# MAJOR PROJECT ASSESSMENT: Dargues Reef Gold Project (10\_0054)

Director-General's Environmental Assessment Report Addendum

July 2011

Figure 4.26
 SIMULATED PIEZOMETRIC
 DRAWDOWN - END YEAR 5

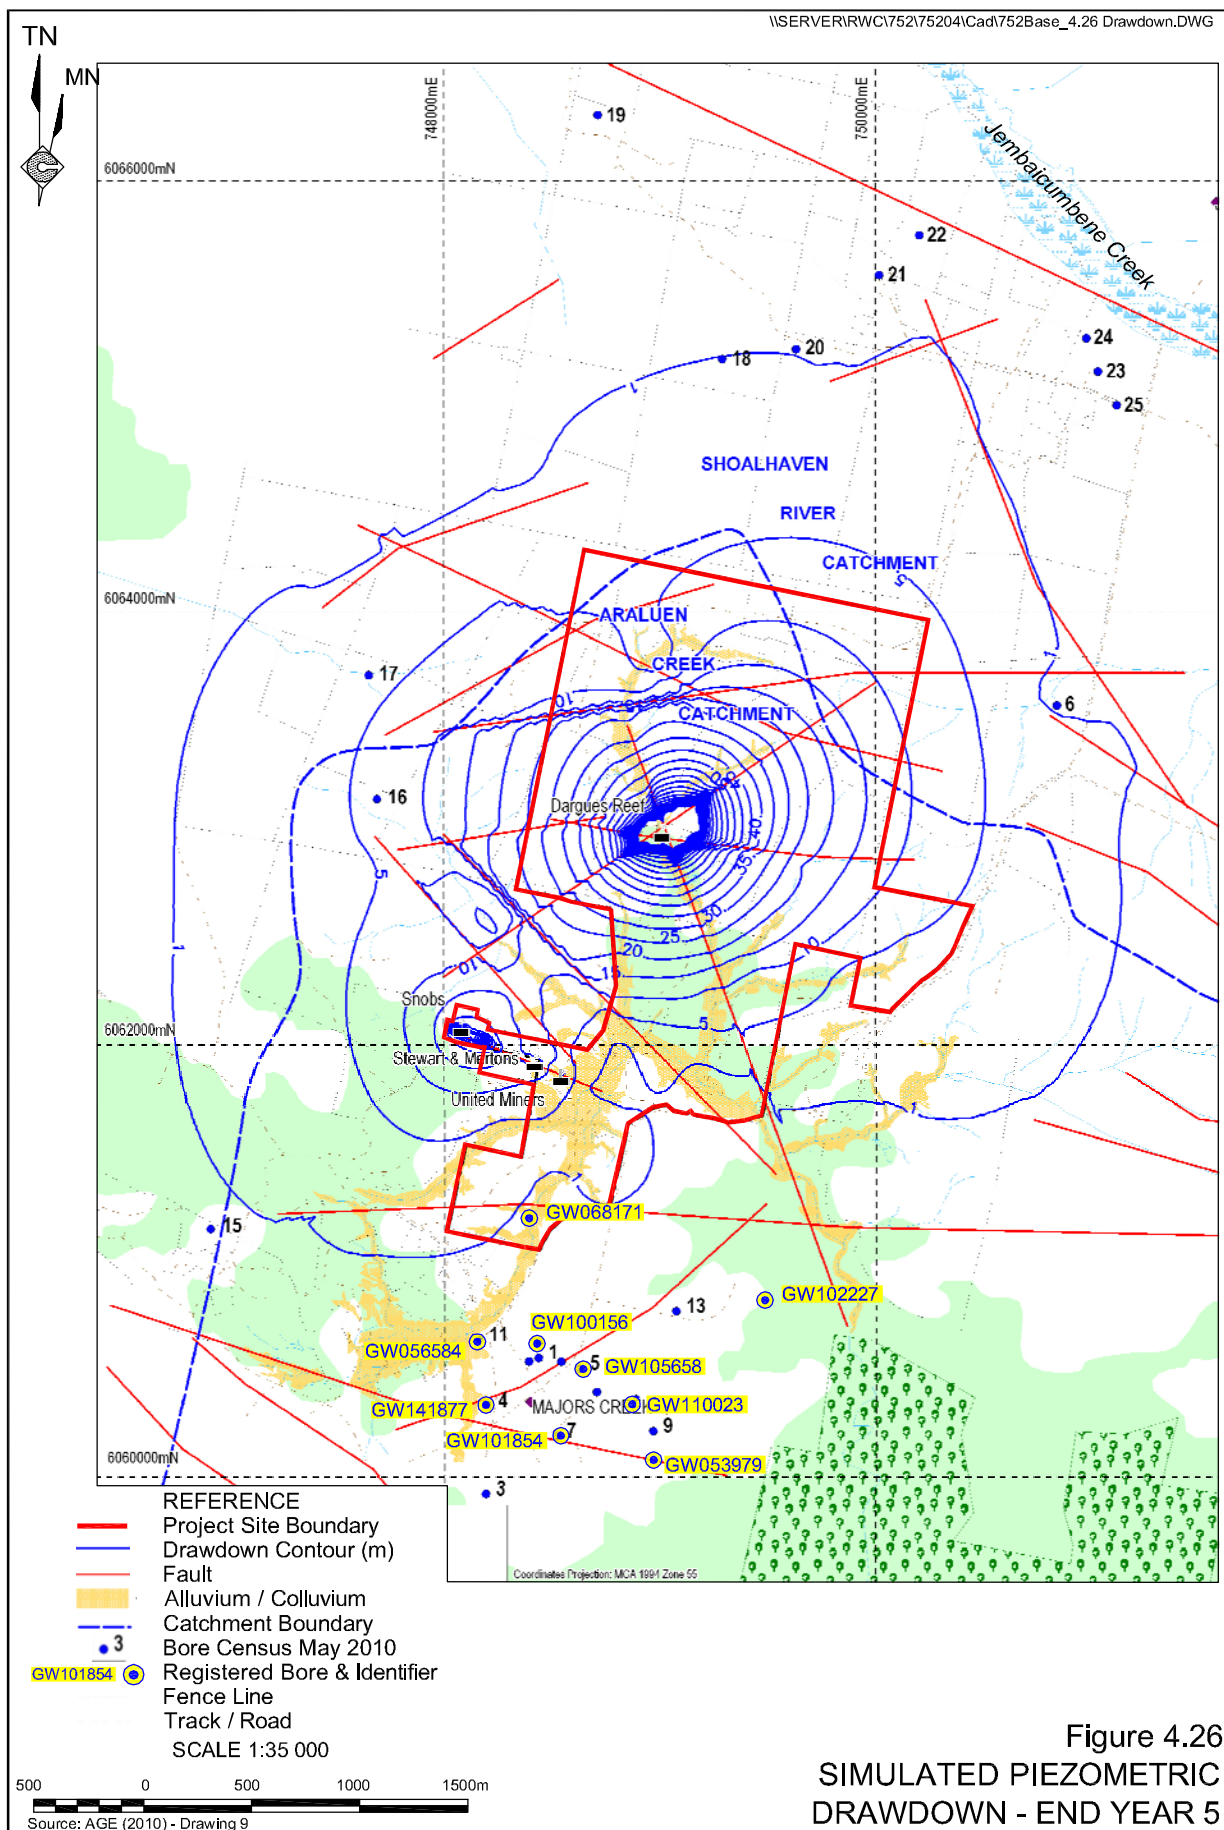
On p.125 of the RTS, the Proponent gives a non-response regarding potential impacts on households that draw water from below the project site. How has the Department satisfied itself that there would be no impact on these households?

The predicted worst-case drawdown associated with the project is shown in Figure 4.26 of the EA (refer to Figure 3). The figure shows that groundwater extraction from the mine and from the historic workings would result in a 1m drawdown contour extending approximately 2.5km from the mine. The groundwater assessment indicated that 2 privately owned bores would be impacted (i.e. within the 1m drawdown contour) and 5 more potentially impacted (i.e. just outside the 1m drawdown contour).

Condition 23, Schedule 3 requires that the Proponent supply compensatory water to any owner of privately-owned land whose water entitlements are adversely impacted.

The Proponent has commenced negotiations with the landowners to compensate for the bore water loss. Potential outcomes may include deepening or re-equipping the bores, drilling new holes or providing water from the mine water supply for the duration of the anticipated impacts.
